From: Elizabeth Nijkamp
Sent: Wednesday, January 29, 2020 7:18 AM
To: Jennifer Irvine
Cc: Daniel Torres; Nina Ruiz
Subject: RE: ROW dedication----Tanja Curtis MS-19-005

From: Nina Ruiz <NinaRuiz@elpasoco.com>
Sent: Monday, November 25, 2019 6:24 AM
To: Jennifer Irvine <jenniferirvine@elpasoco.com>
Cc: Daniel Torres <DanielTorres@elpasoco.com>
Subject: ROW dedication----Tanja Curtis MS-19-005

FINAL PLAT
CURTIS SUBDIVISION FILING NO. 1
 A PORTION OF THE SOUTHWEST QUARTER OF
 SECTION 21, TOWNSHIP 11 SOUTH, RANGE 66 WEST OF THE 6TH P.M.
 COUNTY OF EL PASO, STATE OF COLORADO

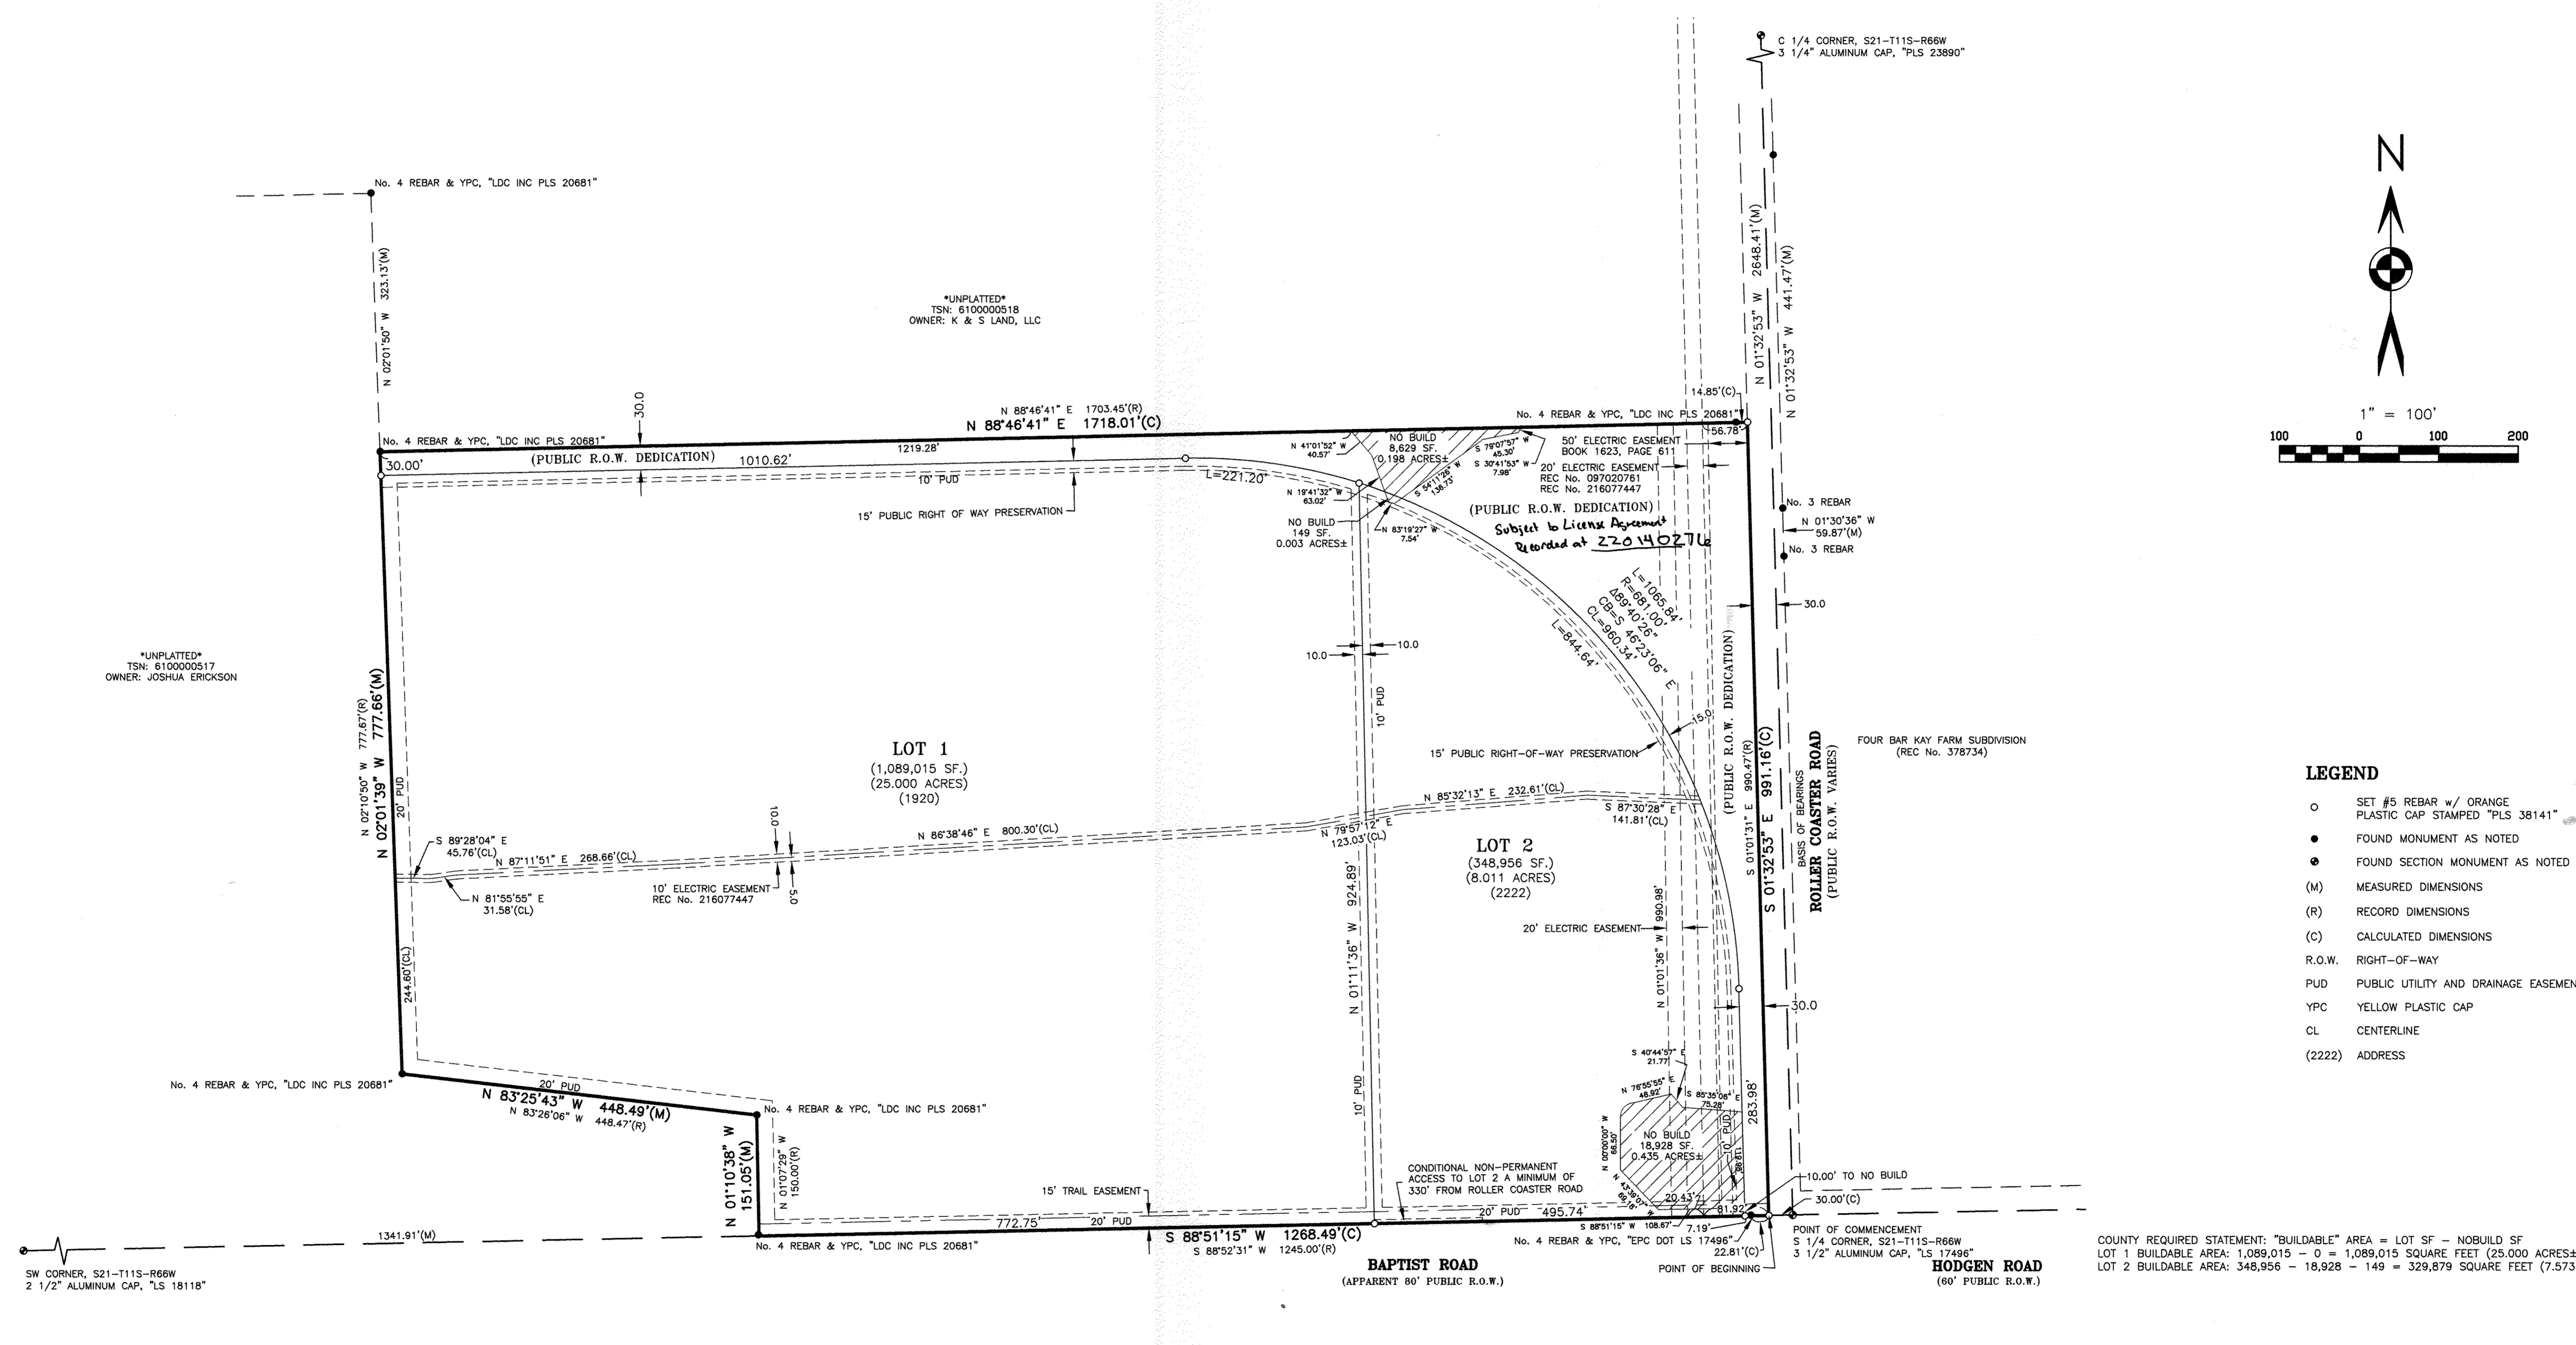
I'm okay with the tracts going to the County. Assume the deeds will be recorded separately conveying the tracts at the same time of the plats and that the resolution for the subdivision will include clause that the Board accepts tracts. I don't particularly like the reverter cause on note 23-if with the design we have to adjust property with adjacent parcels or subdivisions it might not make sense to "give" back to original lot and we may need to dispose in a different way. I can also imagine that the County might not construct a road (if this is note is left on the plat, I would change this to public infrastructure to be more broad) within a timeframe that is reasonable to a property owner and that they might come to the County and request that this be conveyed back (we have had that happen in the past and then had to subsequently purchase property). Maybe the reverter clause if the County disposes of parcel or a portion of the parcel that the adjacent lot will have right of first refusal.

I'm okay with the access being temporarily off Baptist-would prefer that it be co-located into one location but since its late in the review two is okay. Suggest changing plat note 23 to reflect that there shall be no permanent access to Baptist Road for Lot 1 and Lot 2 and that temporary access shall be provided from Baptist Road for lots 1 and 2 and access and driveways shall be relocated by the individual property owners upon notification by the County. Suggest changing the note on page 2 of the plat that references the location for the access to Lot 2 to include the word temporary. Need to also check whether Lot 1 has an access permit-assuming it doesn't, but if it does will need to issue

new one with conditions and make sure that the other permit for access when issued includes conditions. Same conditions should be added to the deviation.

I like the idea of adding condition that if resubdivided that they would need to construct new road.

Hey is additional ROW needed to be dedicated and preserved for Baptist Road to be in conformance with the MTCP? Just wondering if someone looked at that.....?
